Our ref: AN/2026/137473/01-L01
Your ref: H02-0033-26
Date: 02 March 2026

**Construction of new detached dwelling
Land to rear of 53 West Street, Crowland**

Site Section - North/South

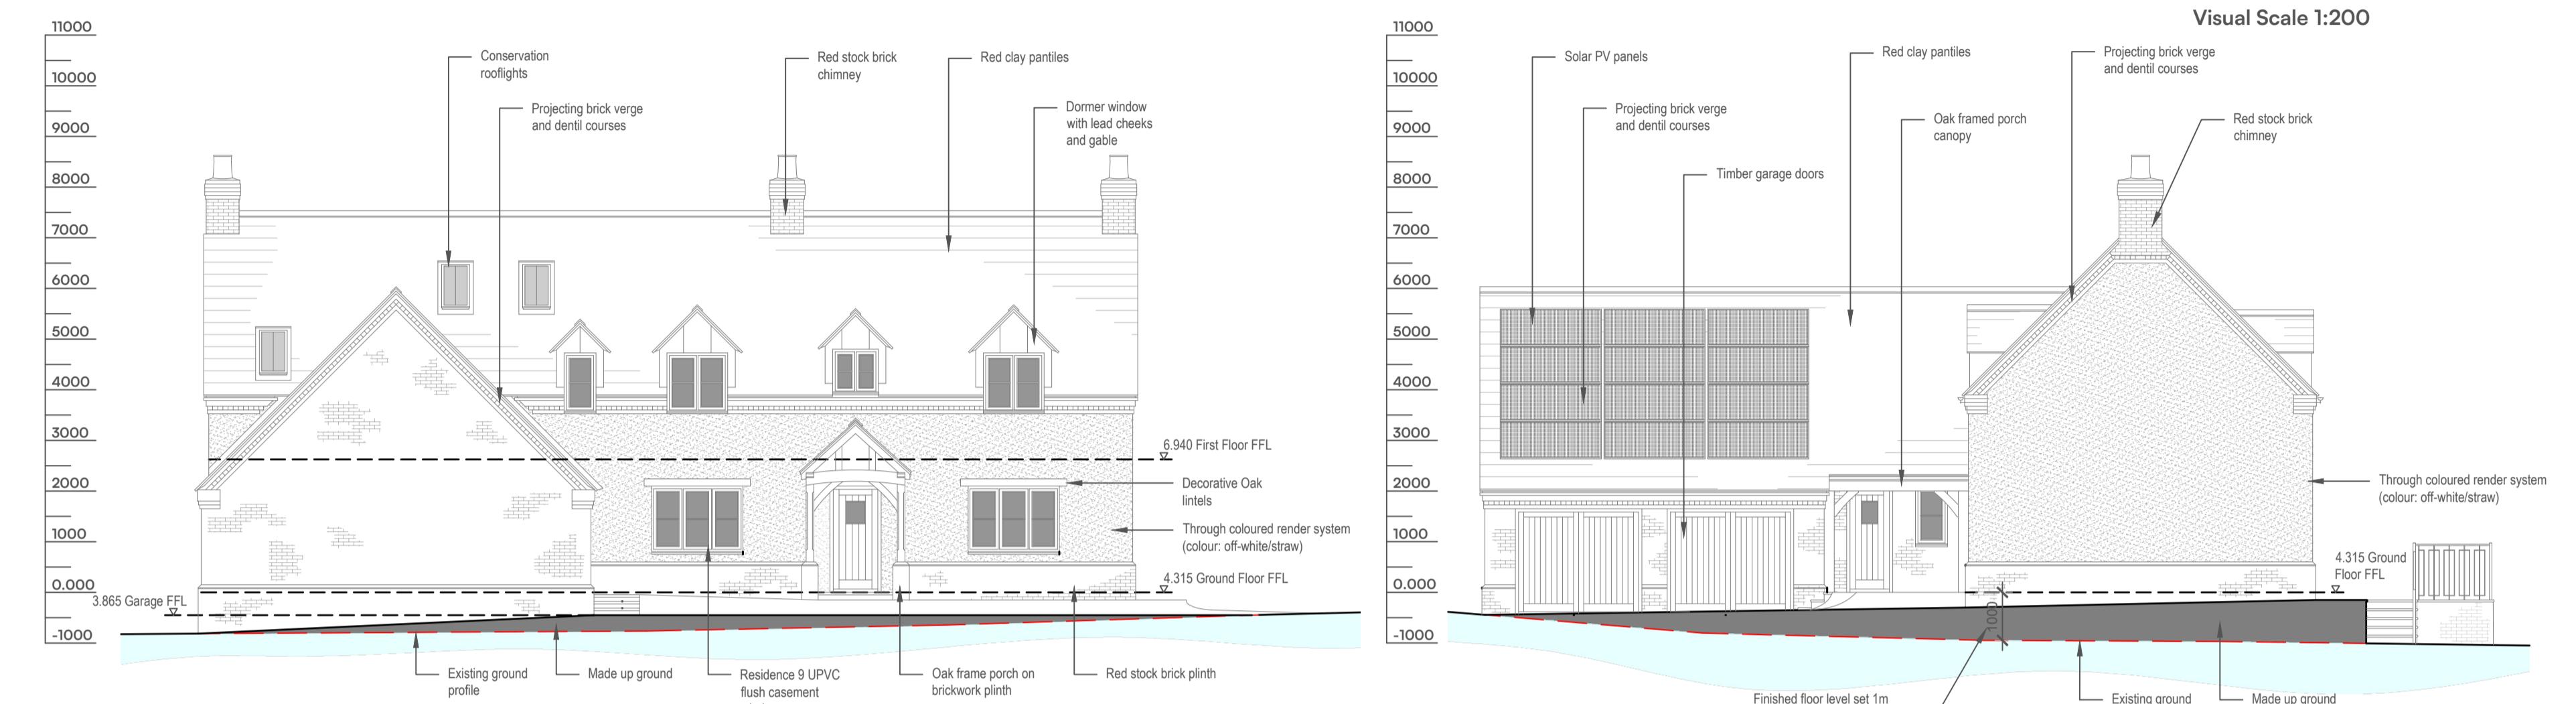
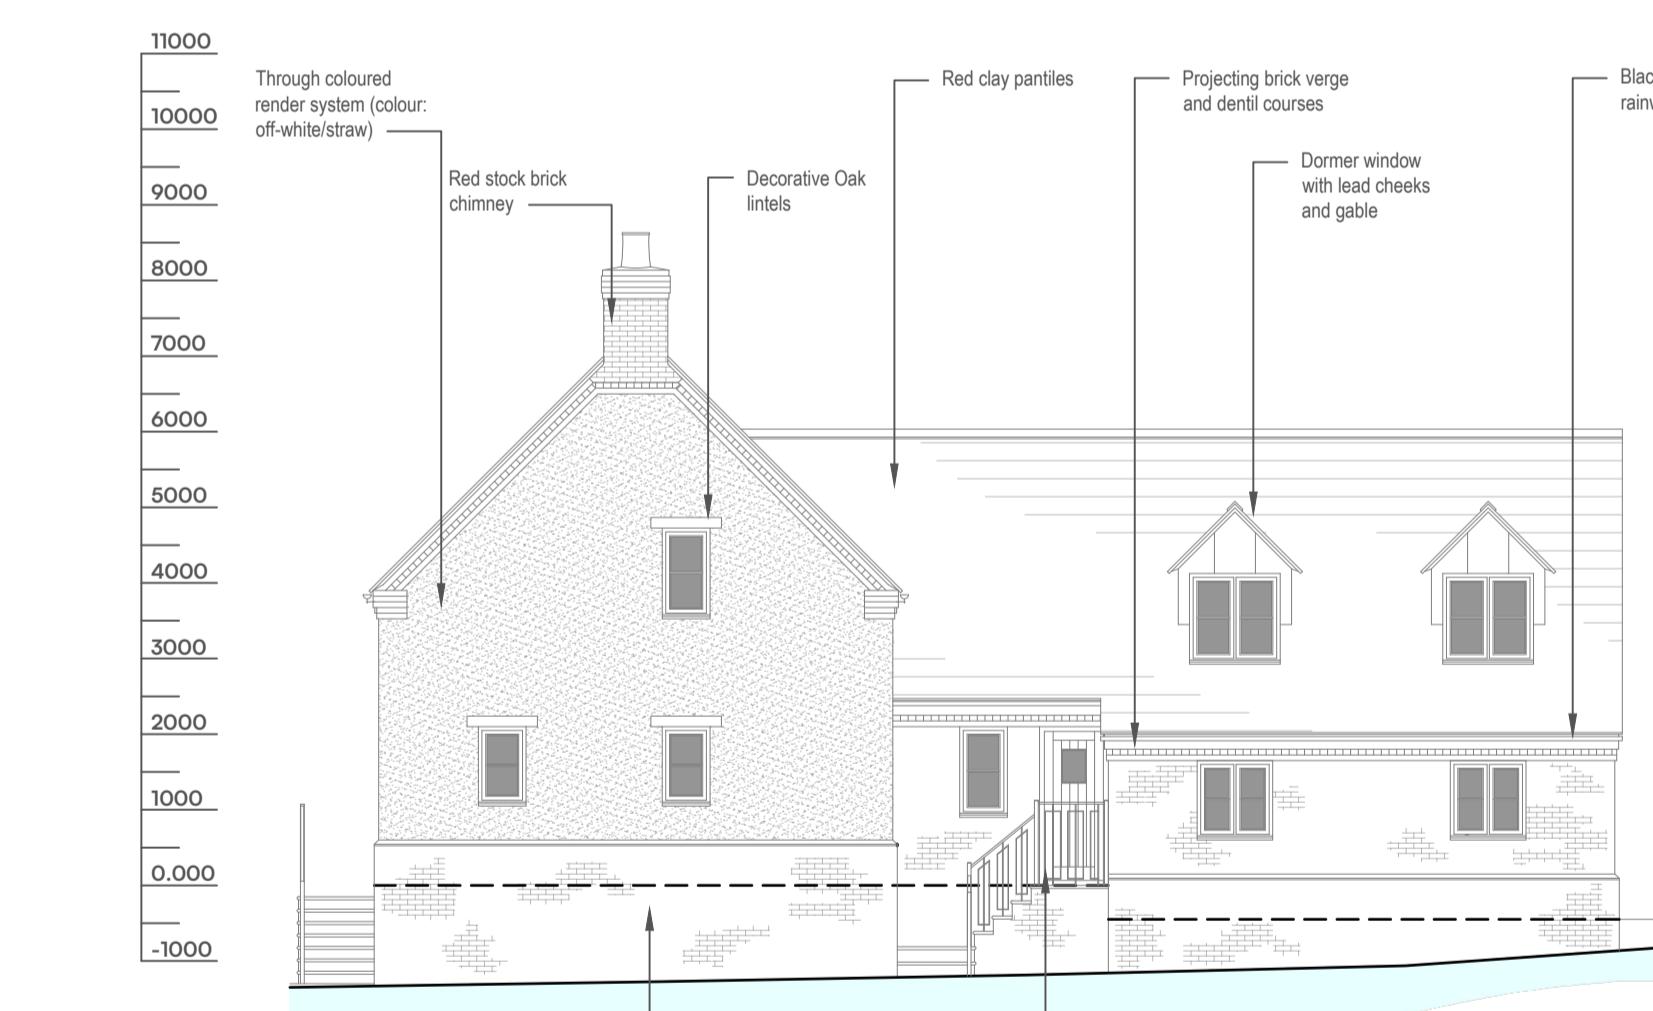
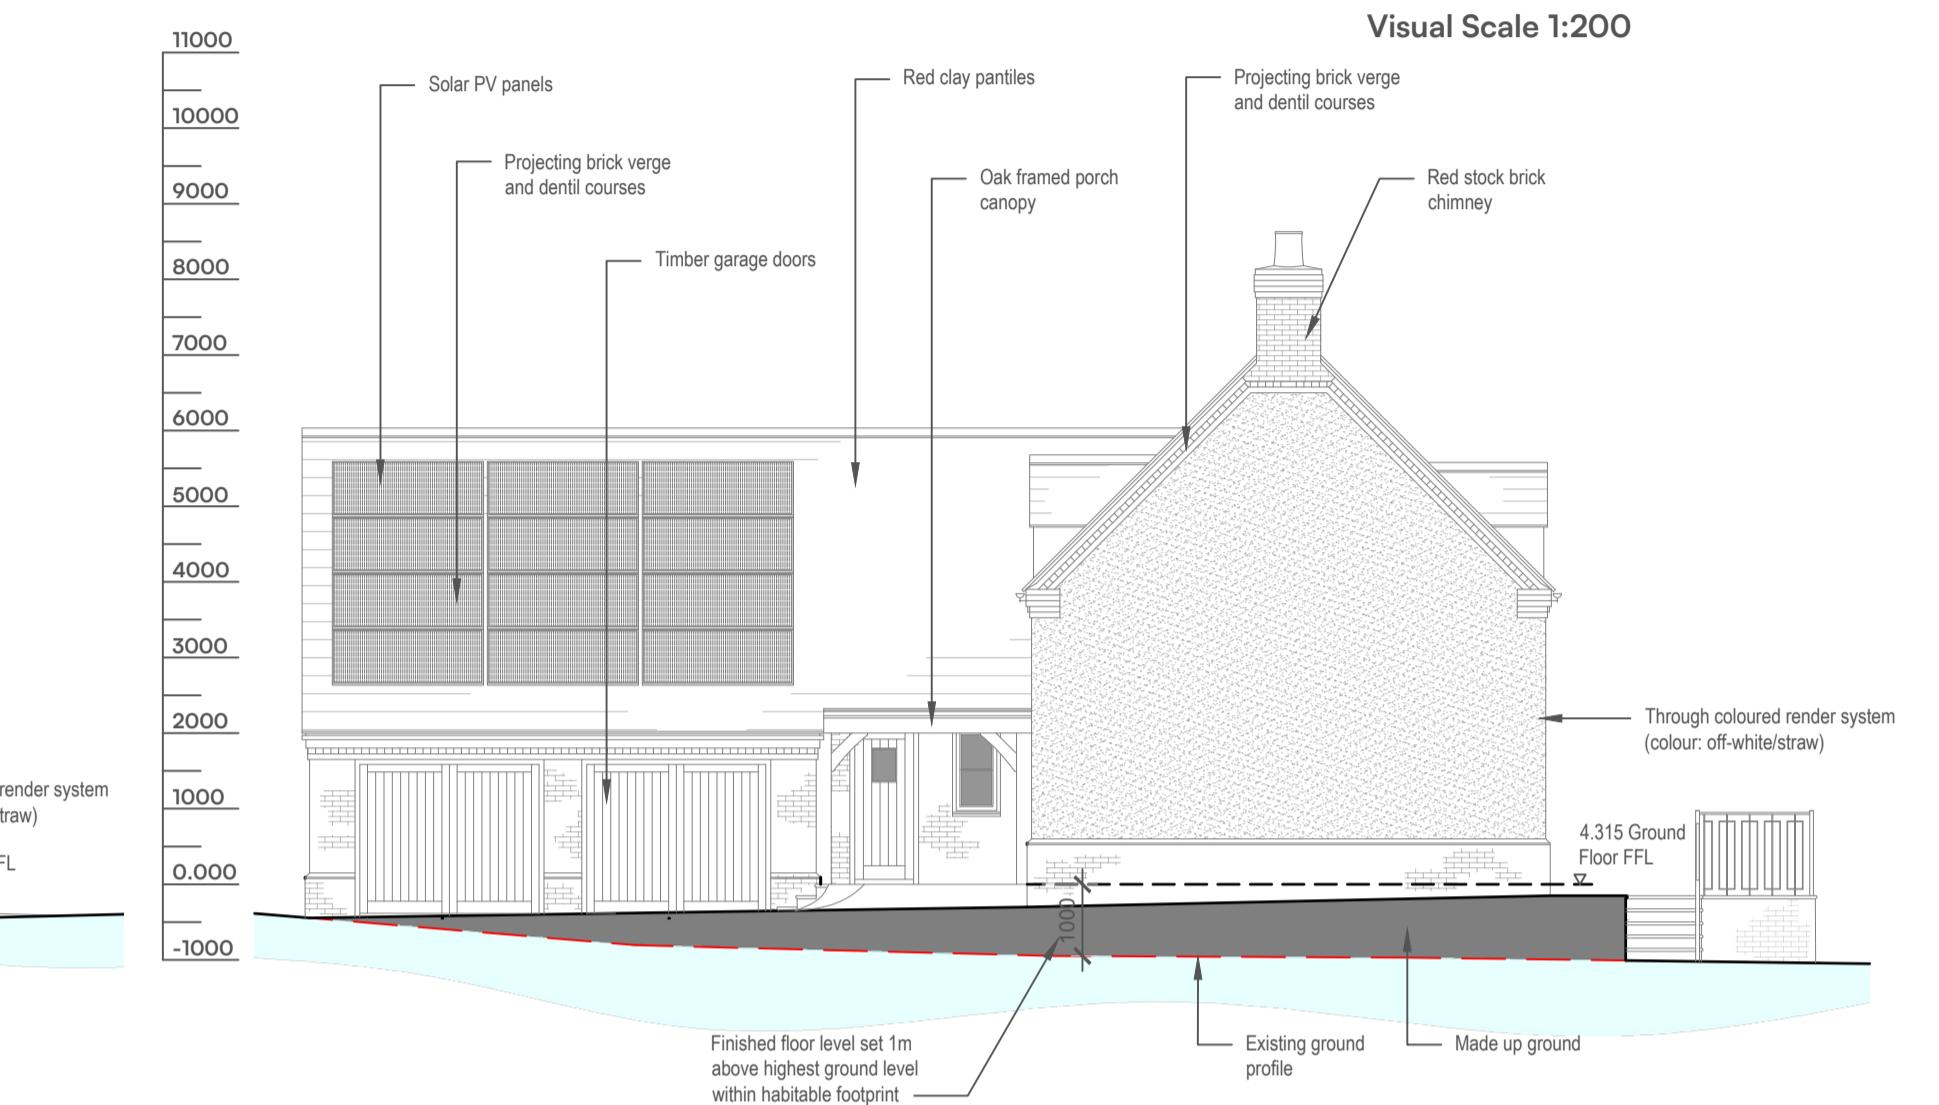
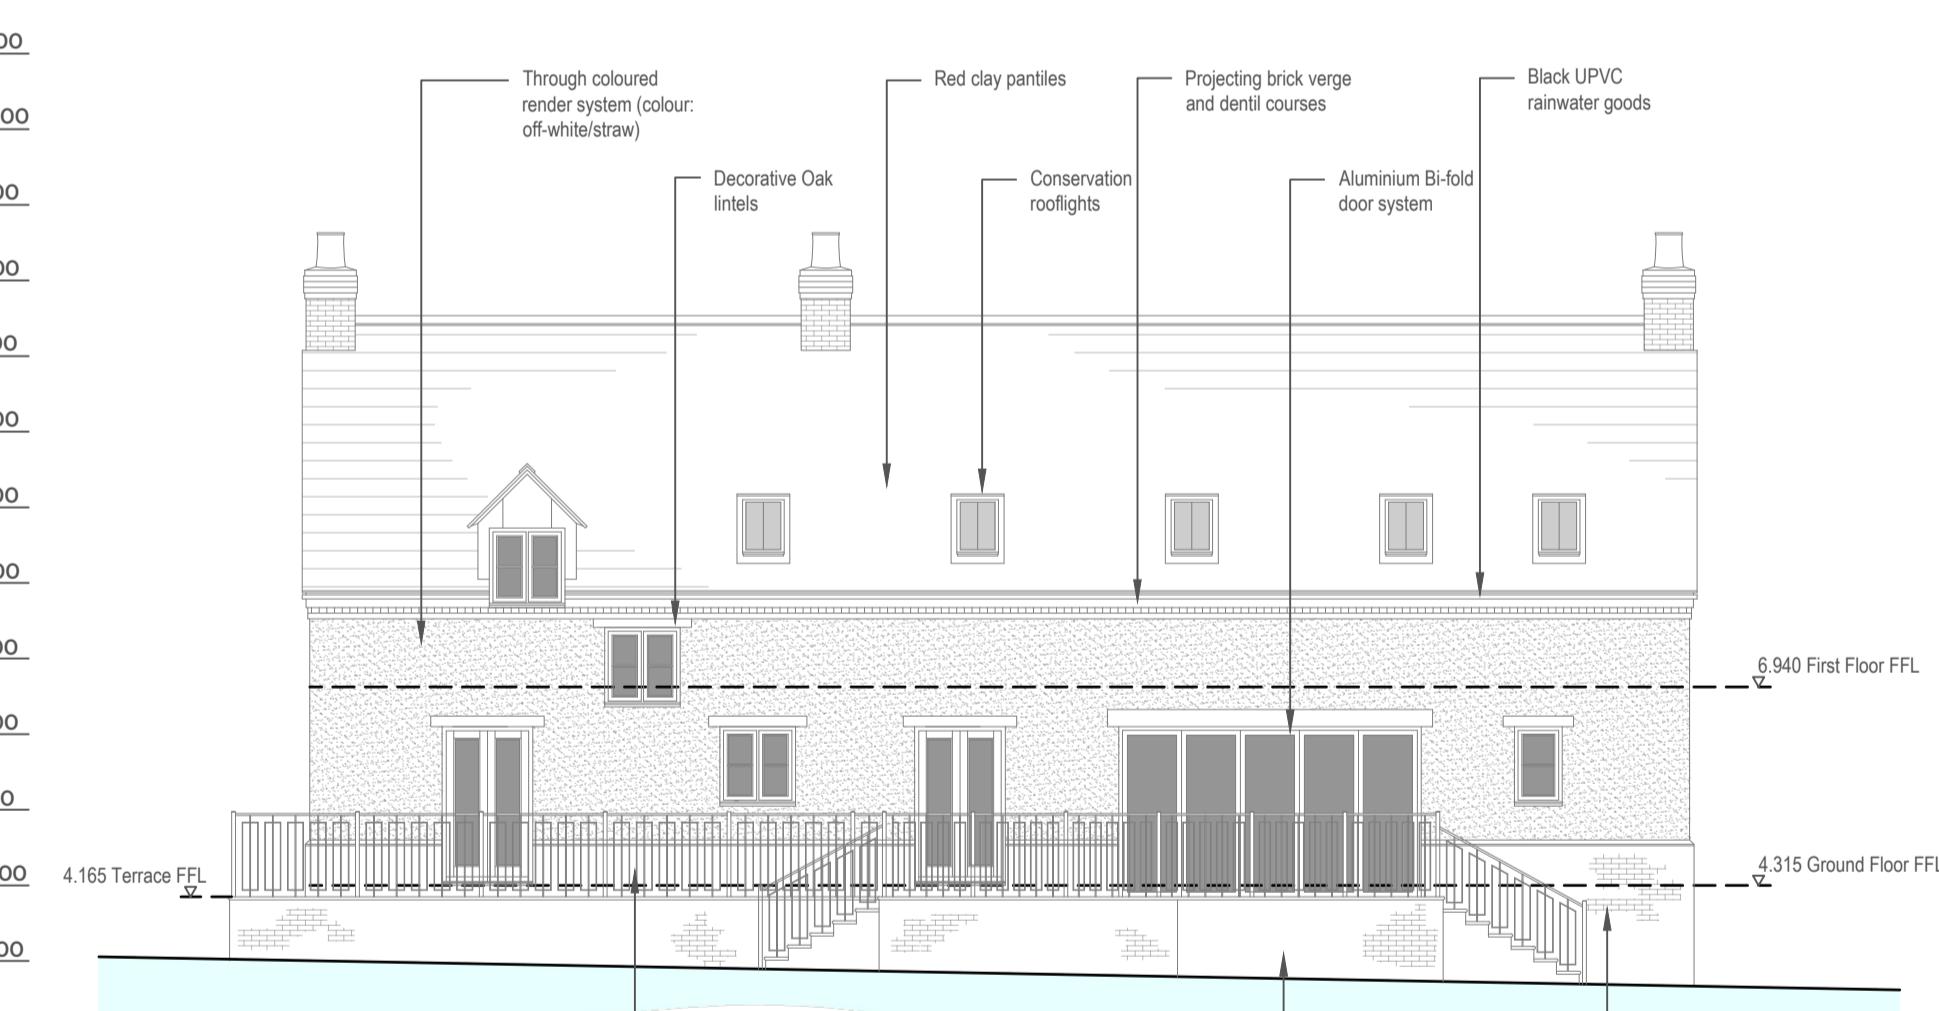
- The dwelling shall have a minimum of two storeys
- The finished floor level shall be set no lower than 4.315 metres above Ordnance Datum (mAOD)
- Demountable defences shall be included up to 0.6m above the finished floor level
- Flood resilient construction shall be incorporated up to 4.9mAOD

SECTION THROUGH WEST BANK - NORTH - SOUTH

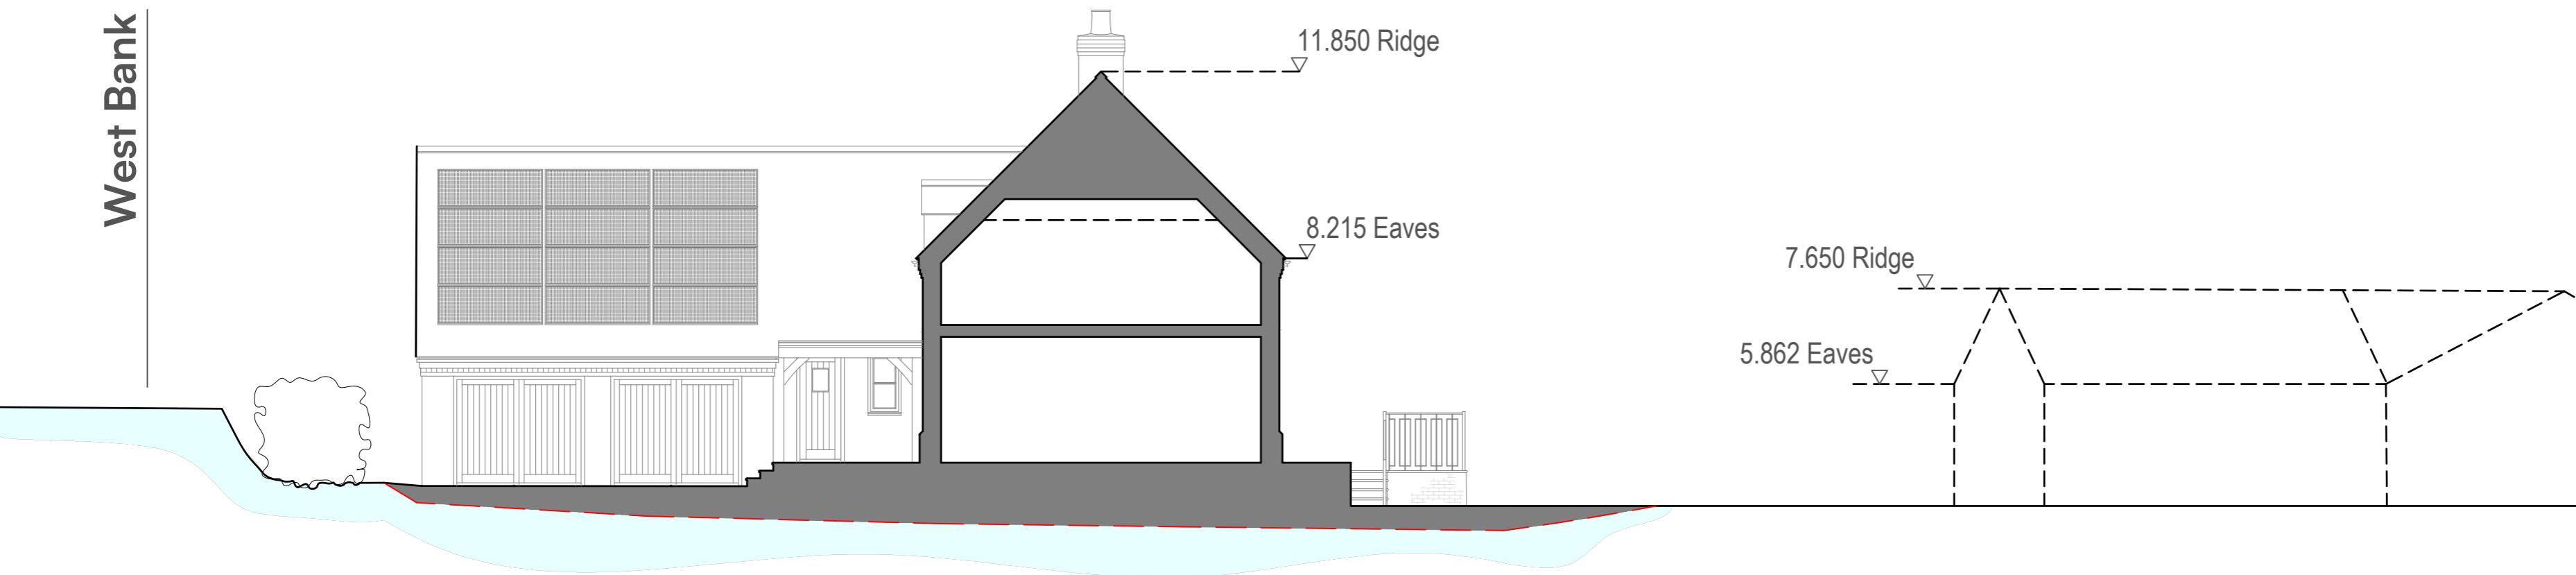
The site is located adjacent to West Bank. West Bank forms part of the dam to the Crowland and Cowbit Flood Storage Reservoir. The Reservoir is classed as being 'High Risk', the highest category and falls within the scope of the Reservoirs Act 1975. The integrity of this wall is imperative to the Flood Storage Reservoirs ability to operate and therefore the reservoir walls are heavily regulated under The Environmental Permitting (England and Wales) Regulations 2016.

A Flood Risk Activity Permit must be acquired for any work on or within 8m of the embankment, for a Reservoirs Panel Engineer to assess, oversee and approve any works to prevent any damages to this wall. As the dwelling is proposed to be within 8m of the embankment a Flood Risk Activity Permit will be required. A permit must be acquired prior to any works undertaken in proximity to the embankment.

We strongly advise the Applicant to consult with us at the earliest opportunity through our pre-application permitting advice service. The Applicant should not assume that a permit will automatically be forthcoming once planning permission has been granted. To discuss our permit requirements, please contact our local Partnerships and Strategic Overview team on psown@environment-agency.gov.uk.
